INTER-OFFICE MEMO

RE: Project #2022-007219/SI-2022-01478 and VA-2022-00235,
Site Plan-EPC Major Amendment and Variance-EPC
Wyoming Apartments- Titan

Note: Staff reviewed the DFT version of the Site Plan-EPC against the EPC version of the Site Plan-EPC, which is the standard, required review.

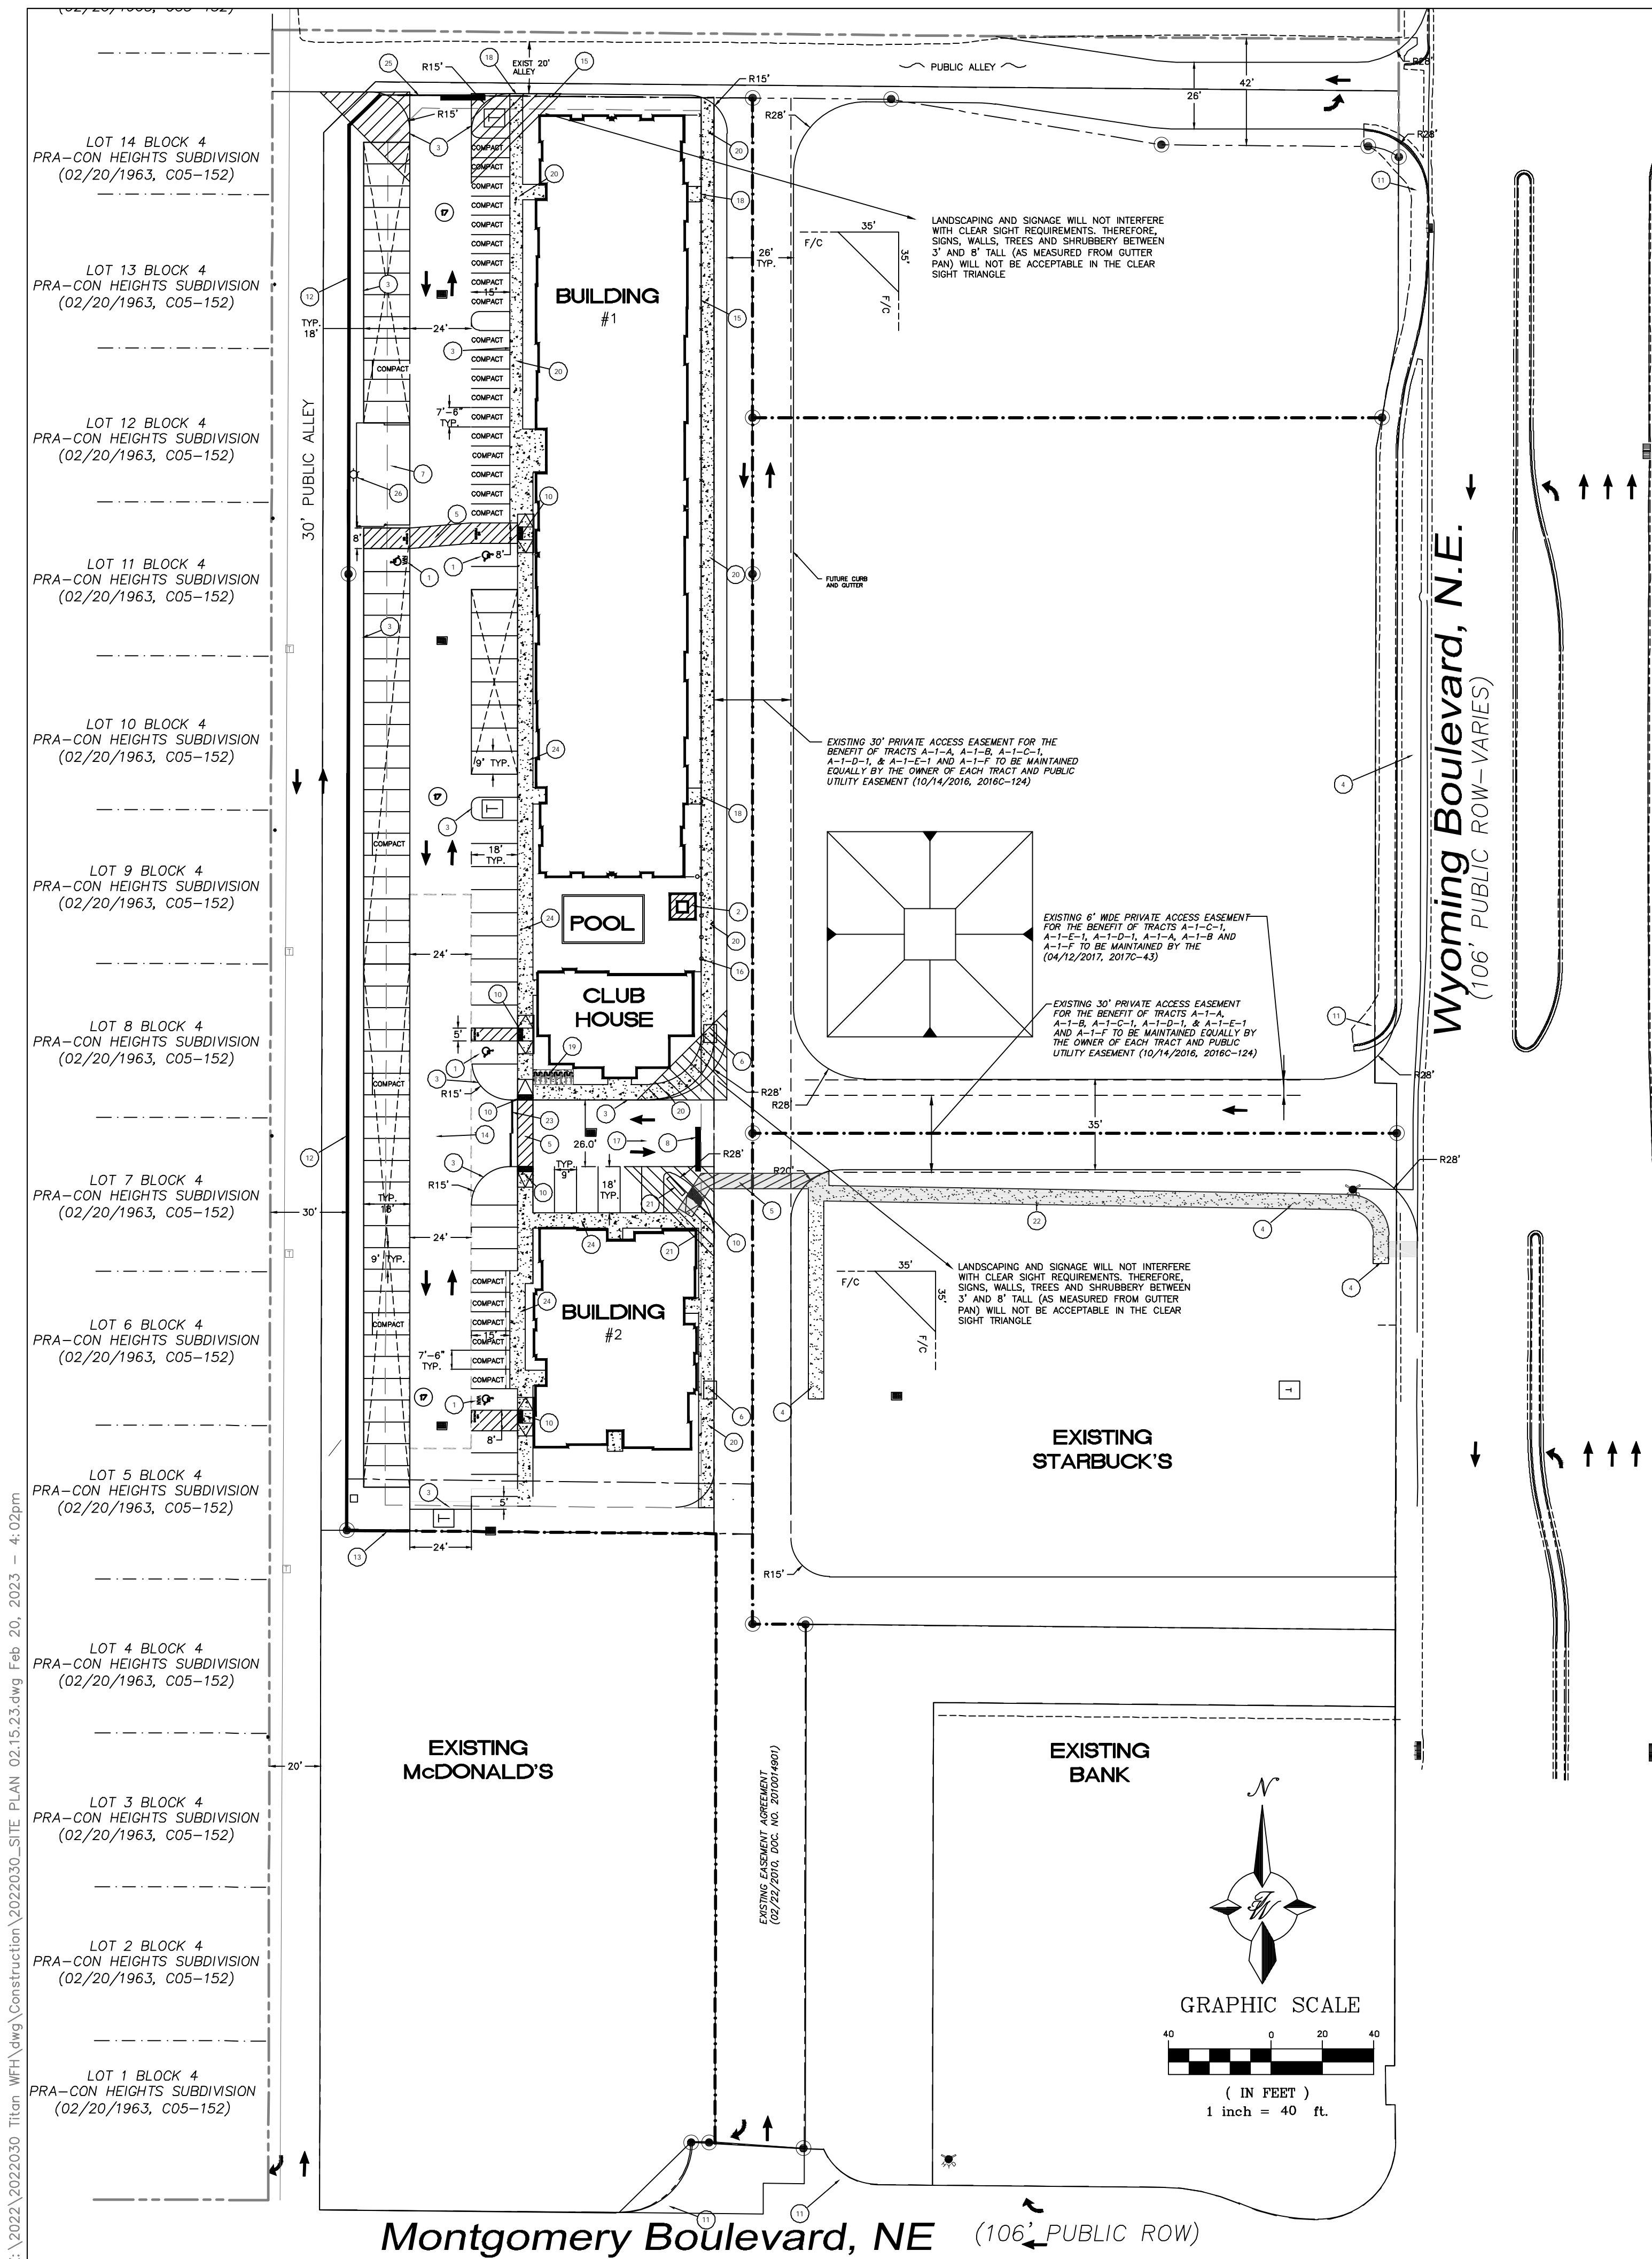
1. Condition 4B: The note stating that the development shall comply with the design standards (and IDO) was added and the parking calculation corrected as required in Condition 4A. However, no motorcycle (MC) spaces are provided. Table 5-5-4 indicates that three MC spaces are required.
2. Condition 4C: New keyed notes are confusing; it would have been more straightforward to place new keyed notes at the end. The May 24, 2023 memo refers to keyed notes 4, 5, 20, 22, and 24, but these don't appear to be related to crosswalks or pedestrian pathways.

3. Condition 5: Same as Condition 4C: the keyed notes referred to in the memo, for pedestrian access, appear to be incorrect.
4. Condition 6- refuse enclosure: The EPC site plan set did not contain detail sheets (it should have) as part of the EPC review. The refuse enclosure detail in the DRF set does not indicate color of the block, stucco, or color and material of the gates.

6. Condition 8- walls and fences: Detail sheet not provided for EPC review. Detail sheet in DFT set shows a light grey, unfinished block wall.
7. Condition 9A: I find only one light pole on the site. Is this the intention?

8. Condition 9B: Keyed note 39 refers to the pool equipment room.
9. Condition 9C-: Unable to verify. Detail sheet was not provided for EPC review. Also, the design standards sheets were omitted from the EPC set, though they were part of that review.

Sheet A-101

1. Keyed note 30 should refer to monument sign, but was changed to property sign (not a defined term).
2. Symbol legend: reinstate carport light, wall-mounted light, gas line.
3. The total square footage totals by floor changed- all four of them. Please reinstate to EPC version.
4. The open space birds-eye diagram was removed and should be put back.
5. Open space provided went from 18,320 to 0.

Sheet Title:  
**Landscape Plan**  
 Sheet Number:  
**LS-01**

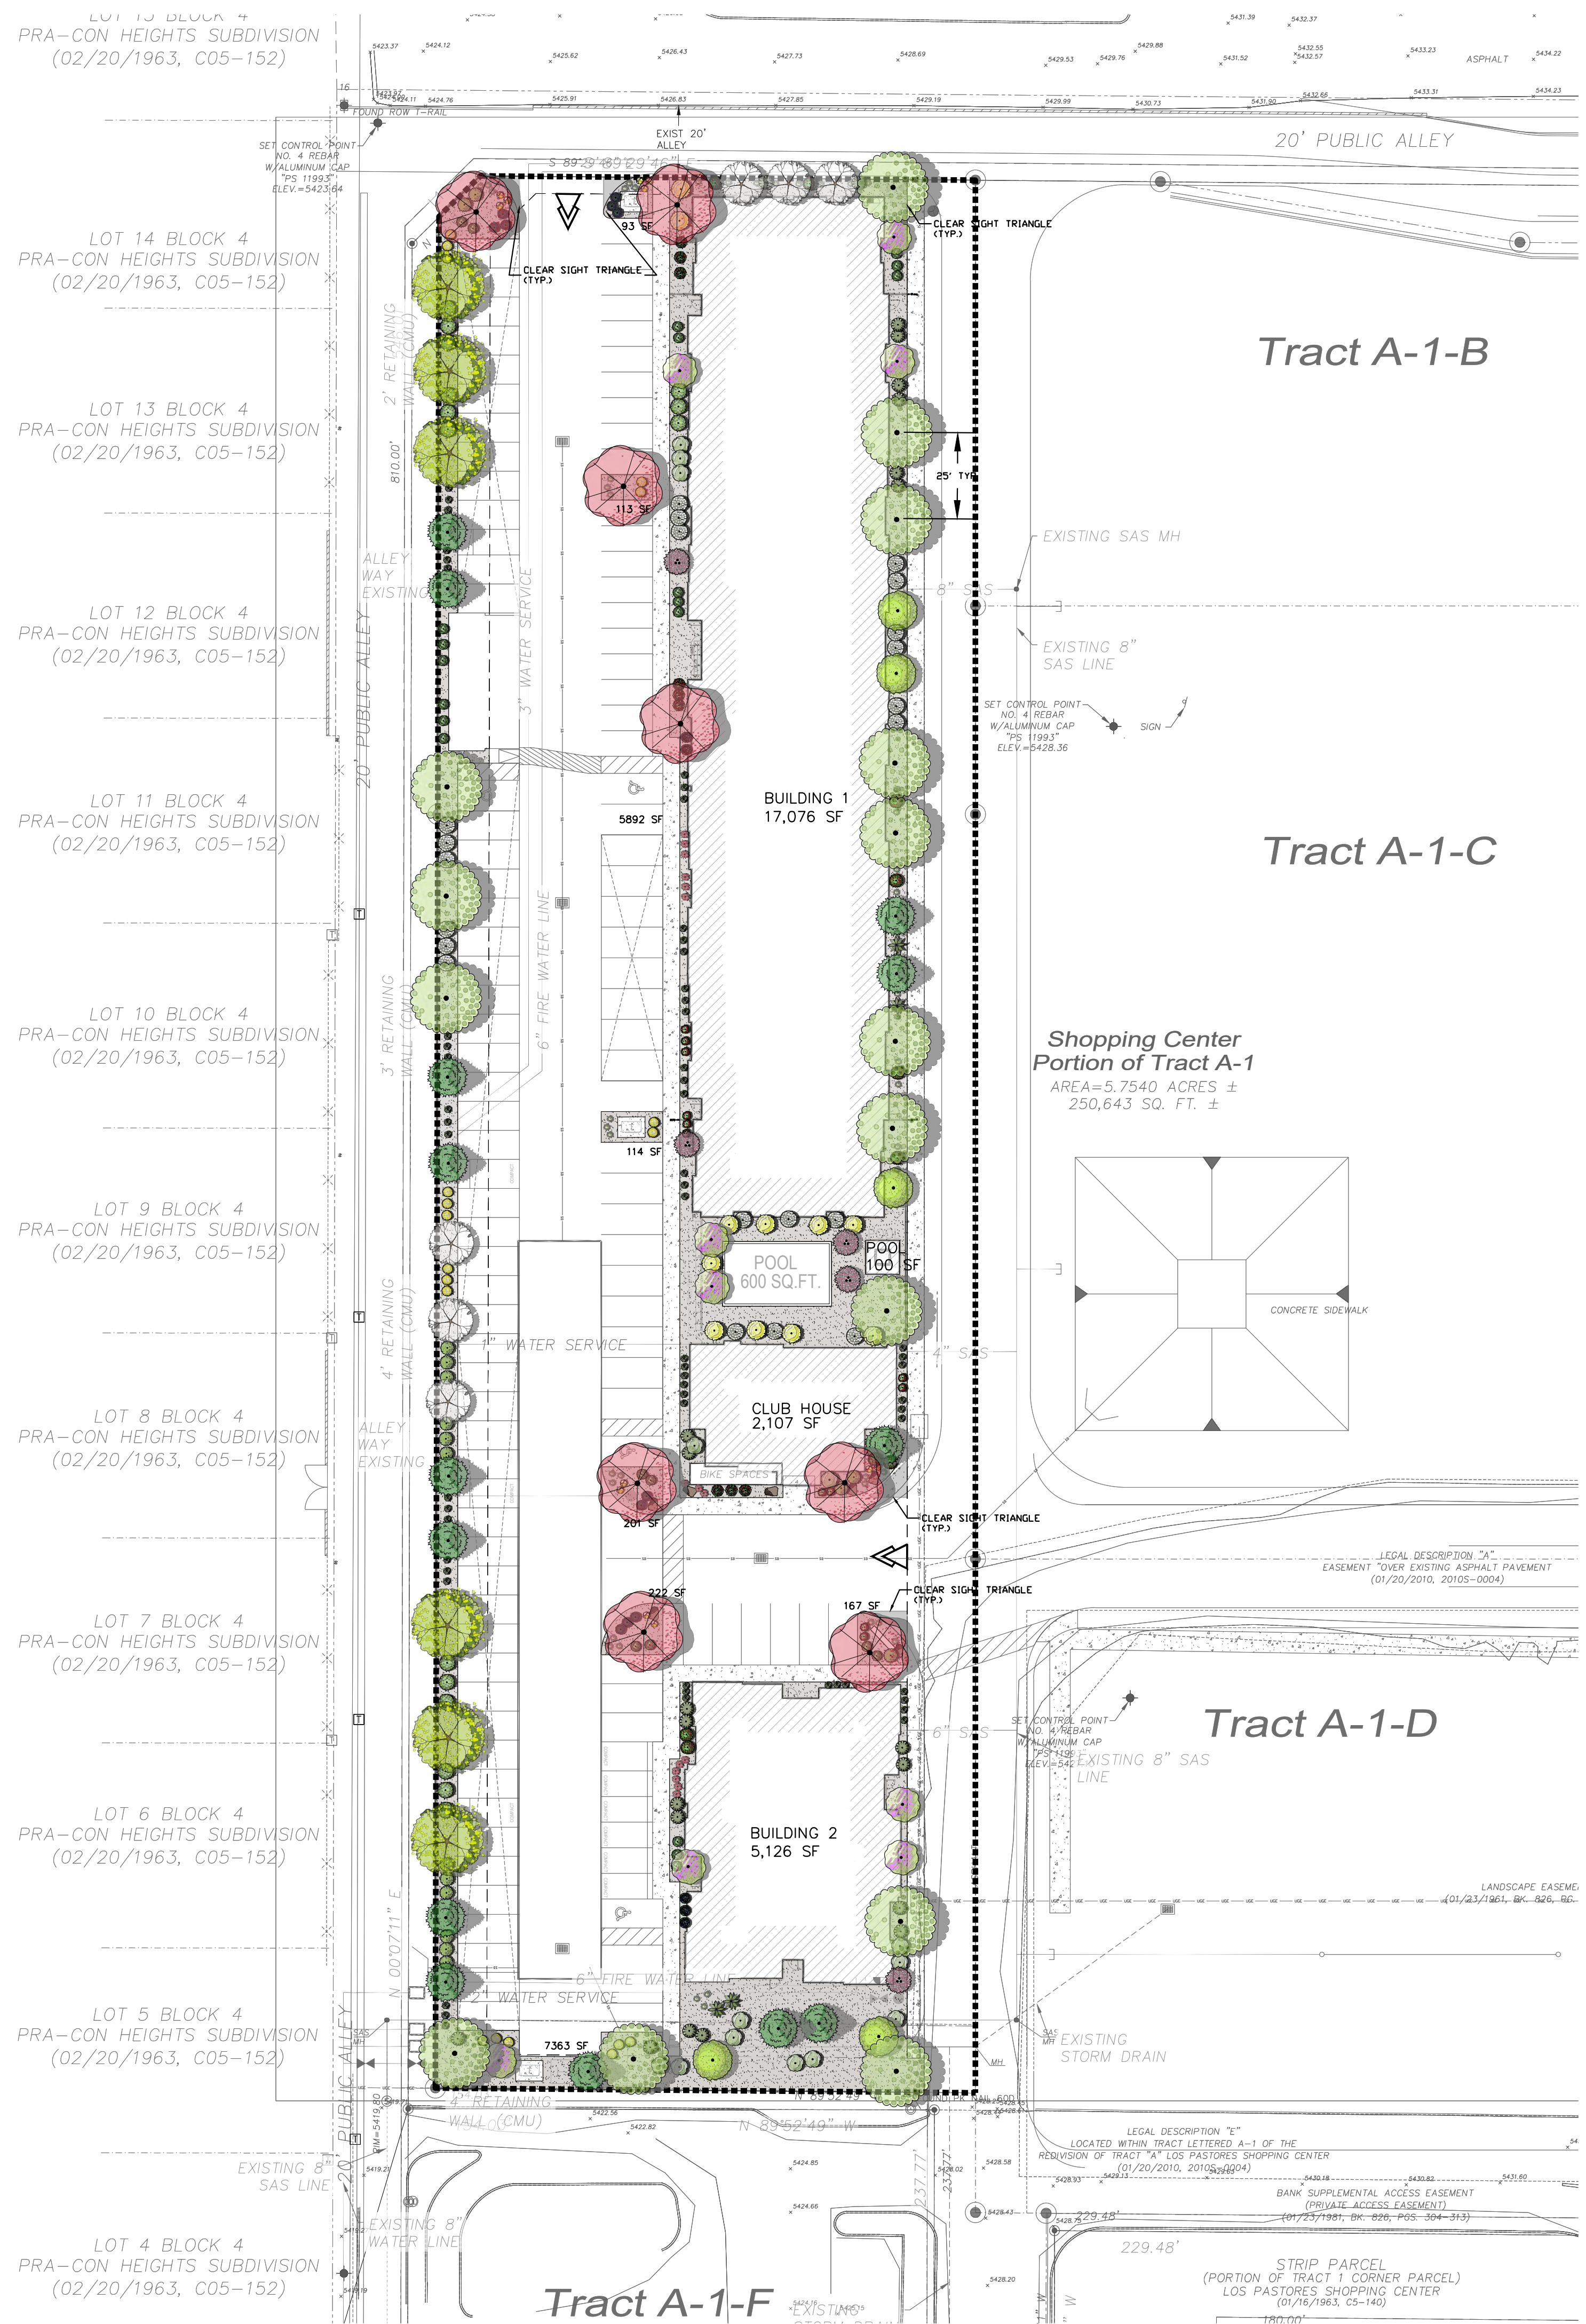
5. Condition 7B: Tree spacing was not dimensioned.
A variance-EPC was granted to allow a narrower landscaping buffer on the western side. This buffer needs to be labeled and dimensioned on the Landscaping Plan.

Landscape Plan

6. Six bushes were removed from the southern landscape buffer and should be reinstated to match the EPC-approved version.
7. The proposed landscape area decreased from 14,232 to 14,165.
8. The proposed vegetation coverage decreased from 58,550 to 54,445 sf.
9. Plant totals decreased for NM privet, Crepe Myrtle, Vitex, Pinon pine.

SHEET CONTENTS:  
 BLDG. TYPE I  
 FRONT ELEVATION  
 SHEET NO.  
**A4.12a**  
 22135

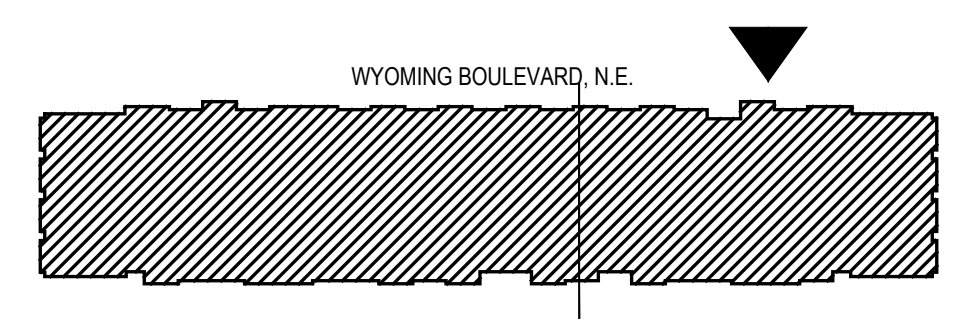
11. Elevations- the notes regarding materials and colors need to be on all elevation sheets, and added to sheets 4.12 and 4.12A.

**08 STANDING SIGN**  
 SCALE: 1/2" = 1'-0"

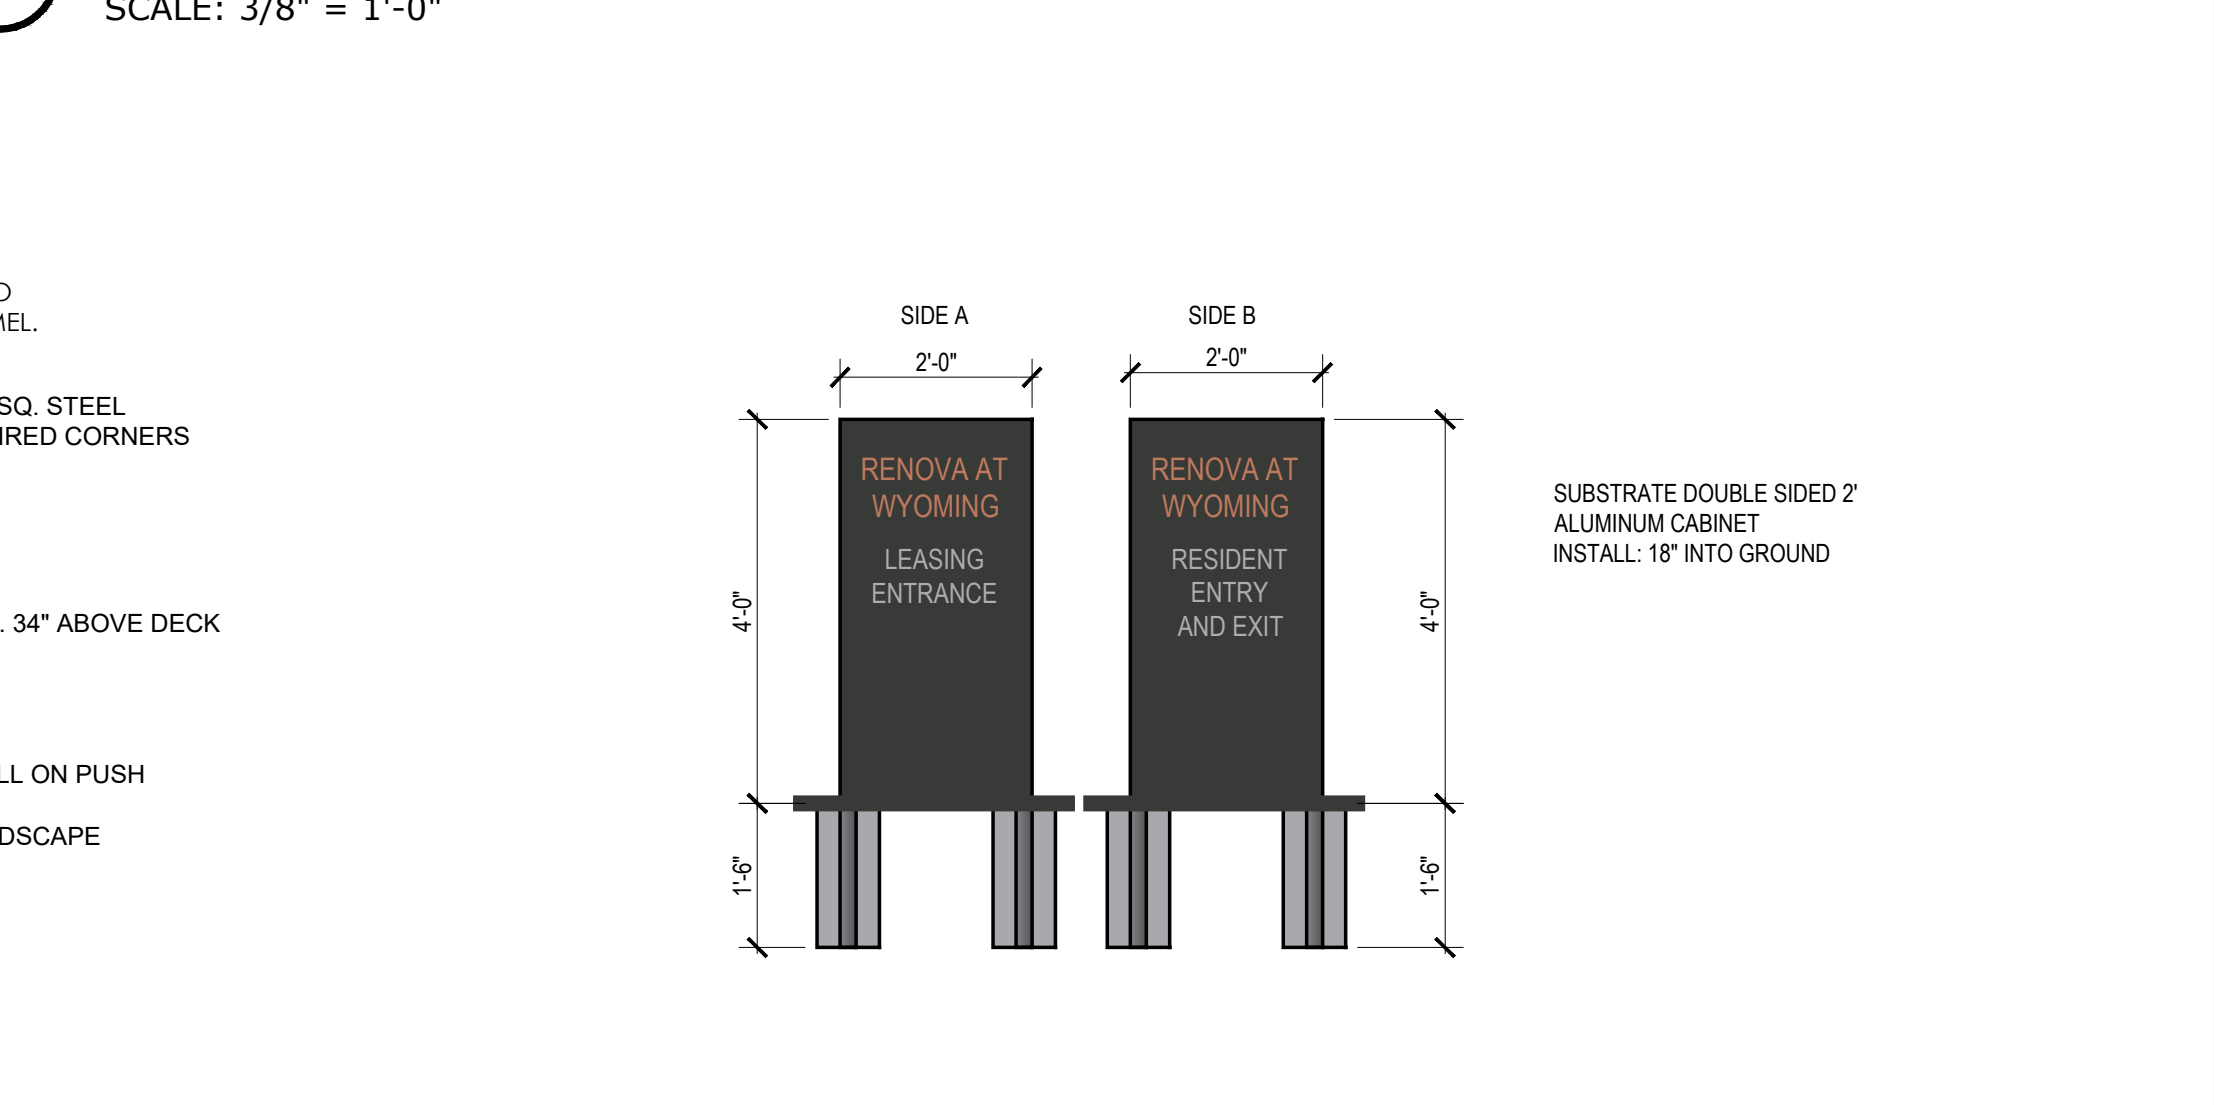
10. Condition 10:
Unable to verify. Detail sheet was not provided for EPC review. Monument sign detail needs to be dimensioned and specify materials and colors.
the math for the building-mounted sign calculation needs to be shown on Sheet A4.22.
